Objection to Planning Application 6/2021/1177/FULL

Project: RO Bridge Road, 52&54 AL8 6UR
Client: Mr. M. Tabrizi
Title: Proposed Site Plans and Elevation
Scale @ A1: As indicated
Drawing No: 1644.P.02

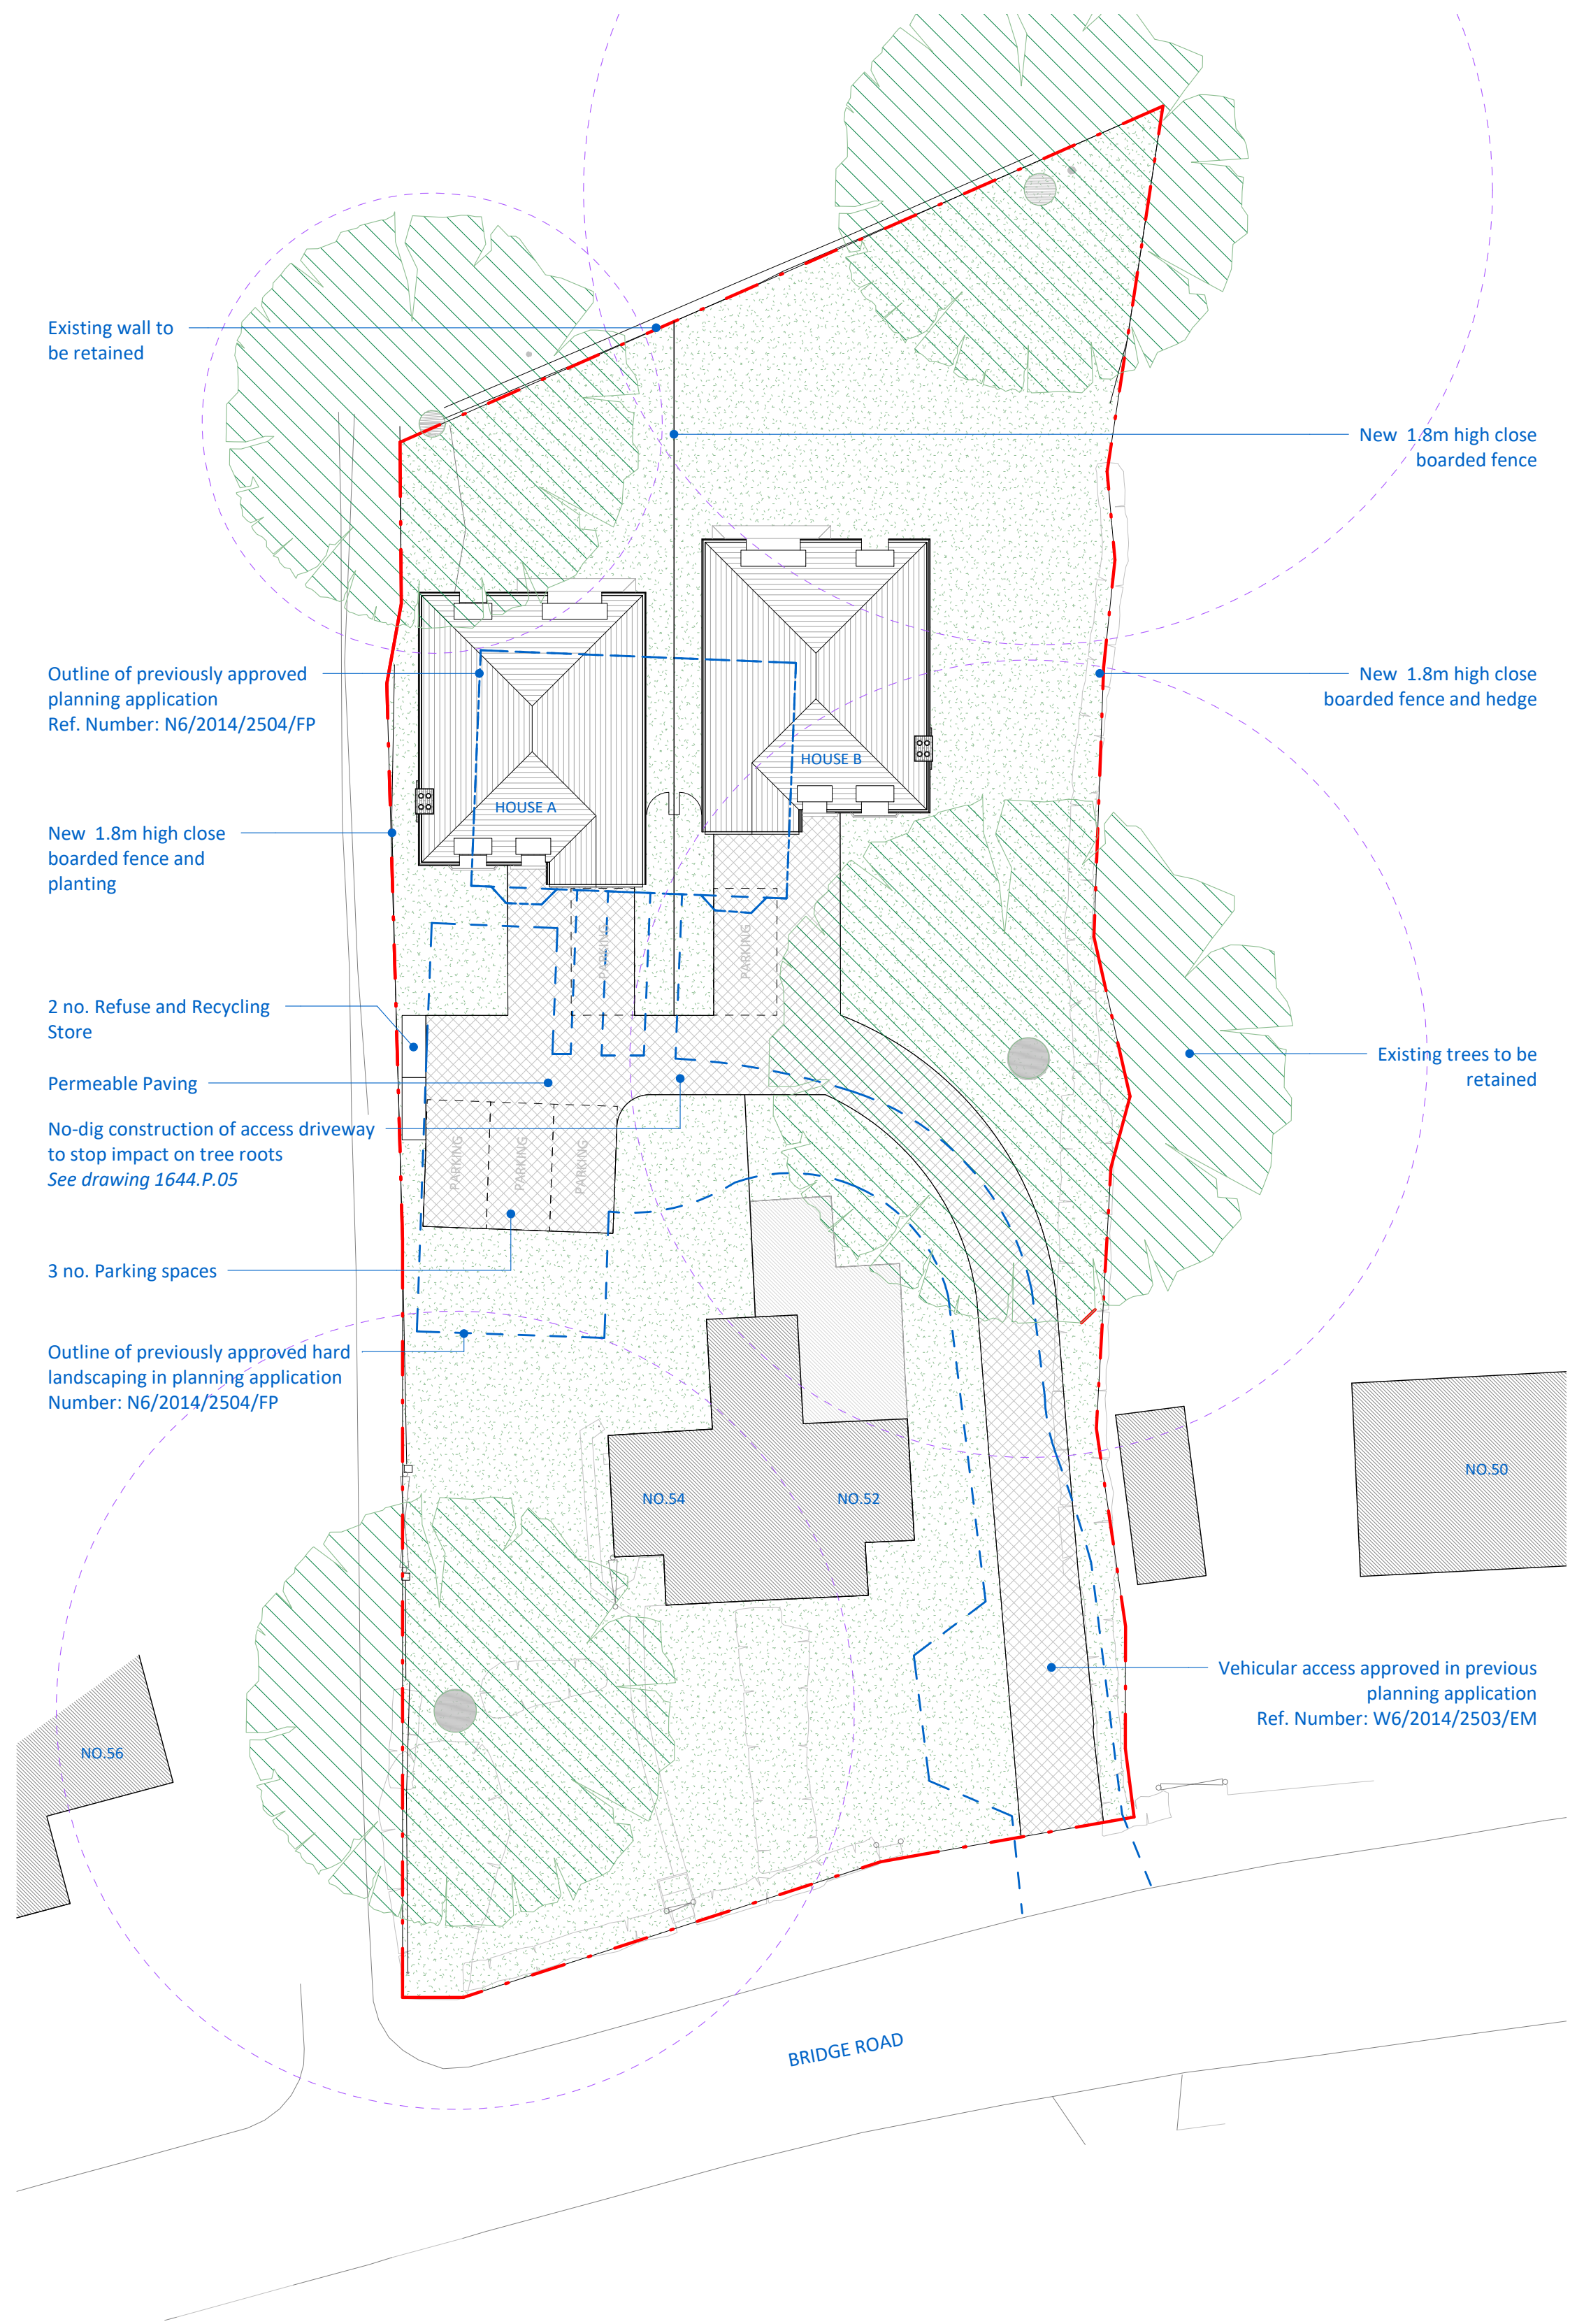
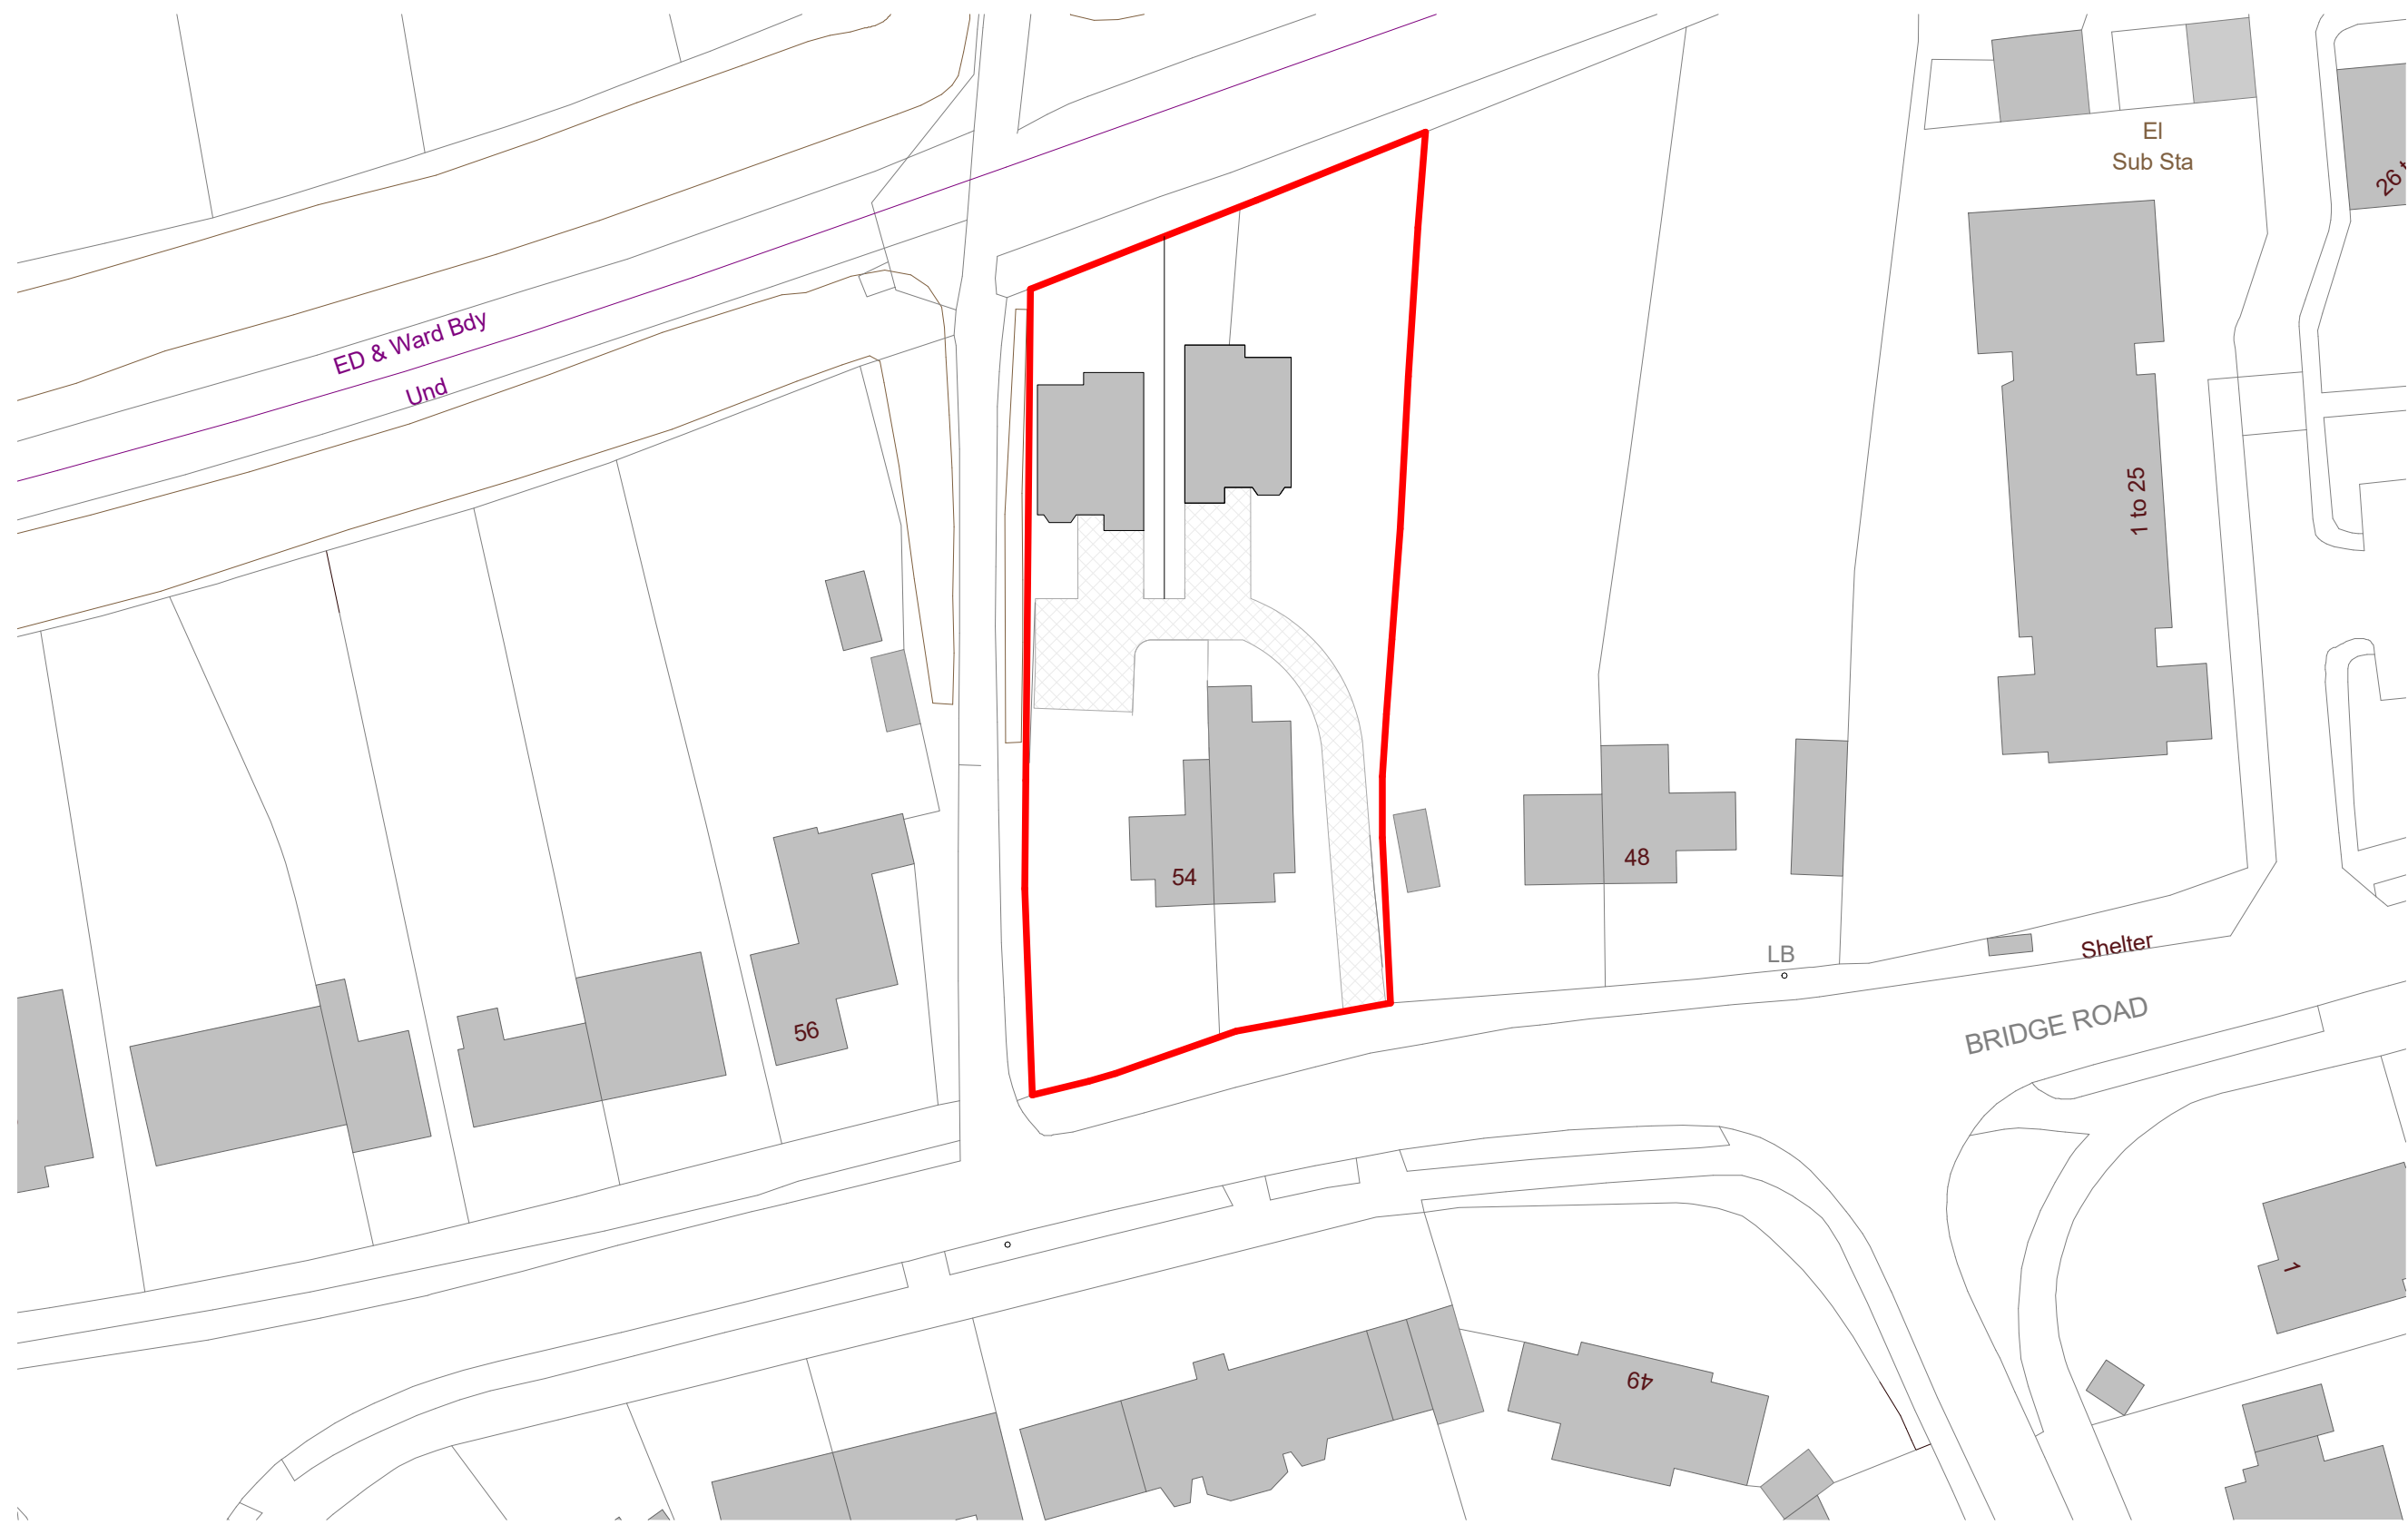
- 1) The proposed dwellings are an over development of the site.
- 2) The dwellings as proposed are crammed into the site and will be very close to the Ayot Greenway, giving little privacy to the owners.
- 3) Natural England and the Forestry Commission have commented on this planning application as follows:-
“We strongly advise the retention of ancient woodland and veteran trees within the application site as they have important roles to perform as local landscape features and possibly as visual screening, as wildlife habitats for woodland species (including NERC Act s41 priority species such as stag beetle) and ecological corridors for mobile species. Depending on the configuration of the proposed development, they may also act as buffers to the designated site.”

Project: RO Bridge Road, 52&54 AL8 6UR
Client: Mr. M. Tabrizi
Title: Tree Impact and Protection Plan
Scale @ A1: As indicated
Drawing No: 1644.P.05

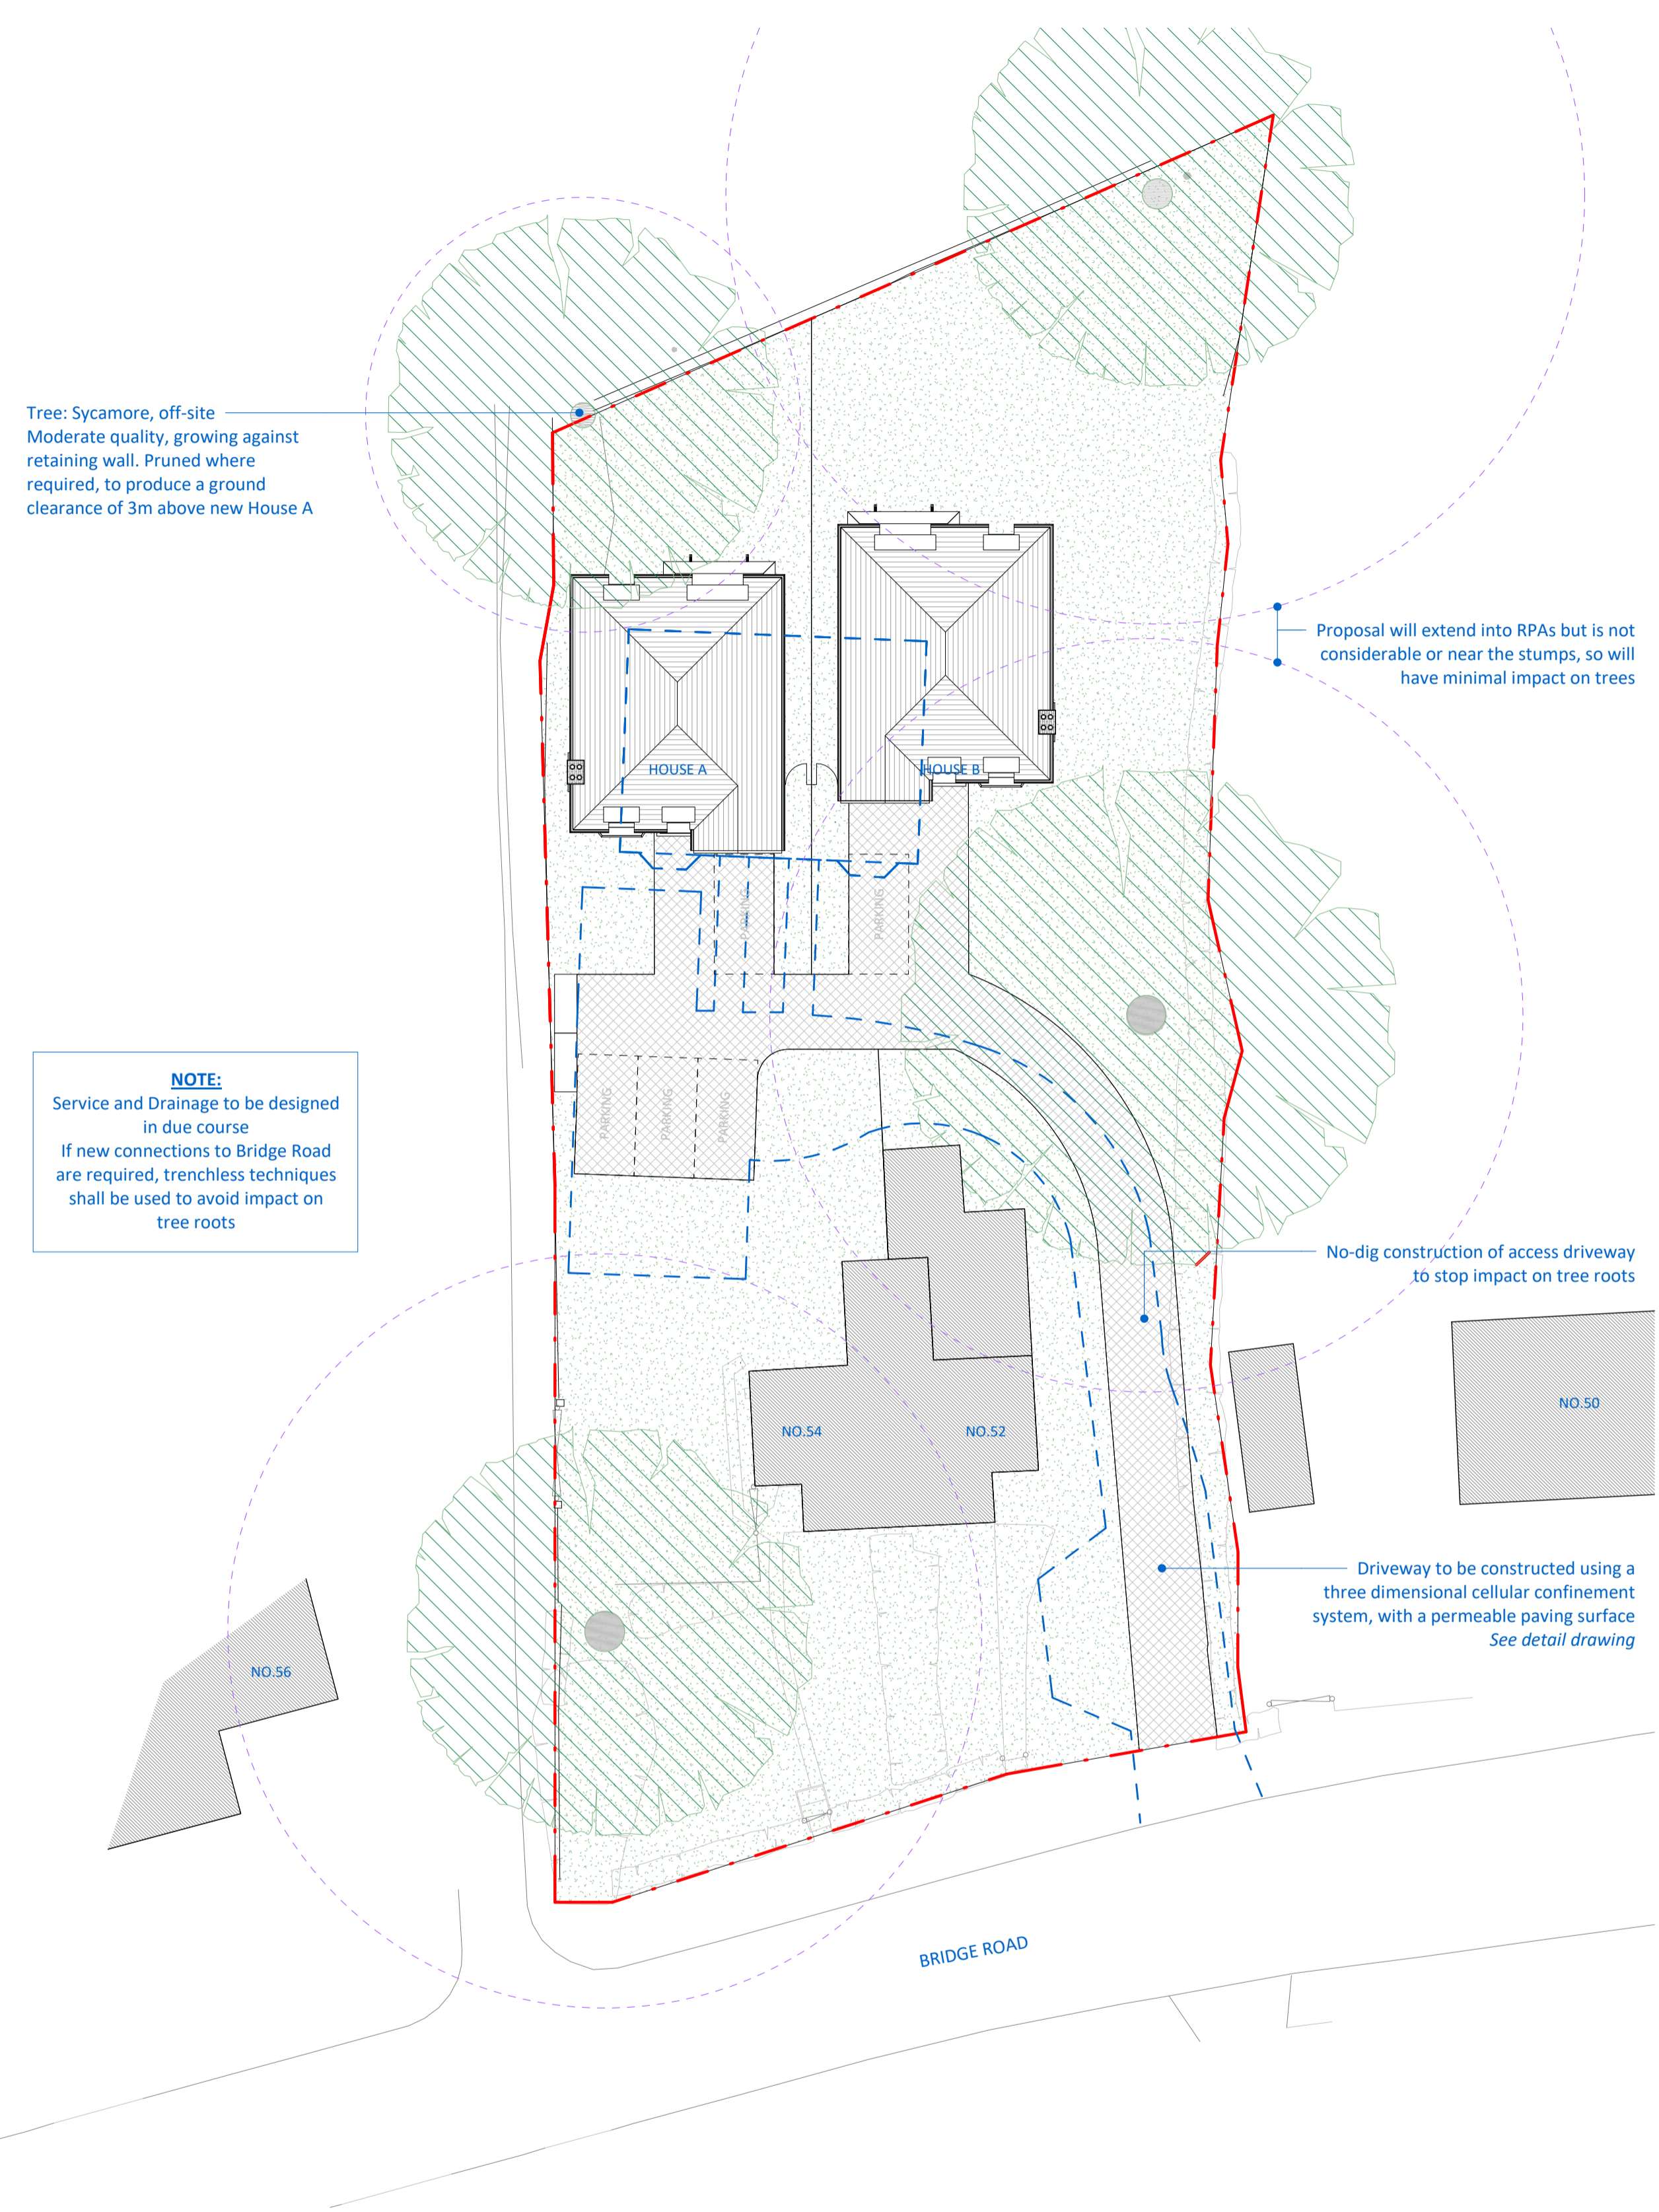
The fact that machinery, materials etc. need to be kept on the site will severely threaten the wellbeing of the veteran trees on the site. The development could also impact on the wellbeing of Sherrardspark Wood, an SSSI and rare example of sessile oak/hornbeam woodland.
